**WEST SUSSEX COUNTY COUNCIL
STRATEGIC PLANNING CONSULTATION**

SUBJECT: AL/47/14/PL - Change of use from agricultural land to provide 4 No permanent plots for travelling show people and a pony paddock. This application is a departure from the Development Plan.

Land at Aldingbourne Farn Shop, Nyton Road, Aldingbourne

Drawing Title: Proposed Site Layout

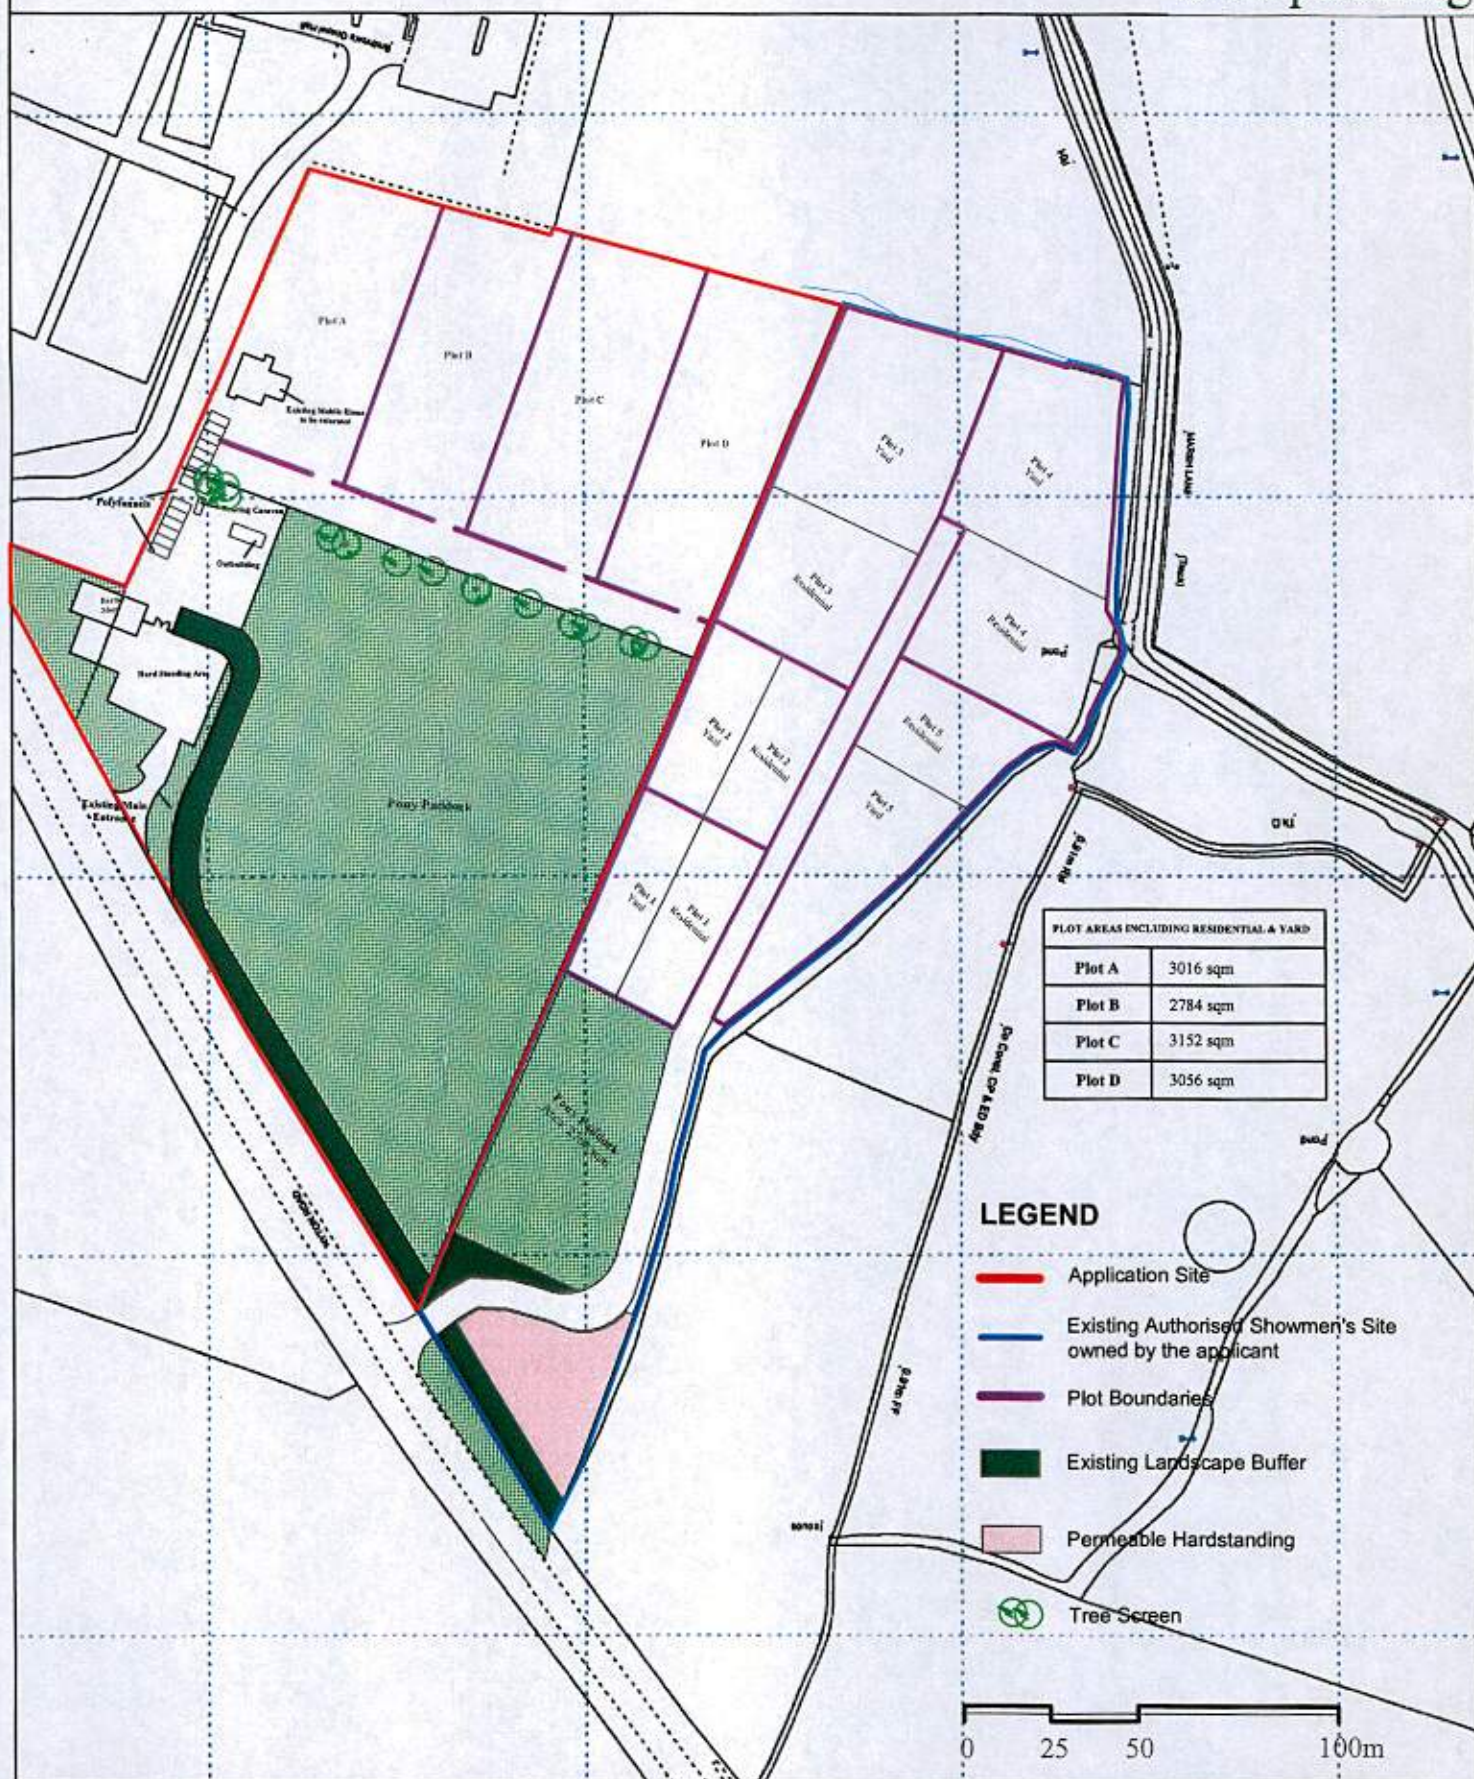
The proposal is for the change of use from agricultural land to provide 4 permanent plots for travelling show people and a pony paddock, and the site will utilise an existing access point onto Nyton Road. From an inspection of the plans alone, there is no apparent visibility issue at the point of access and the most recently available verified accident records reveal there have been no personal injury accidents in the vicinity of the existing point of access.

As with my colleague's previous comments to AL/119/10 and AL/92/10, WSCC would request that the existing access is upgraded, with a heavy duty crossover and a level platform not exceeding a gradient of 1:30 for the first 10m into the site, measured from the nearside edge of carriageway. Furthermore, any gates at the site should also be set back 10m into the site.
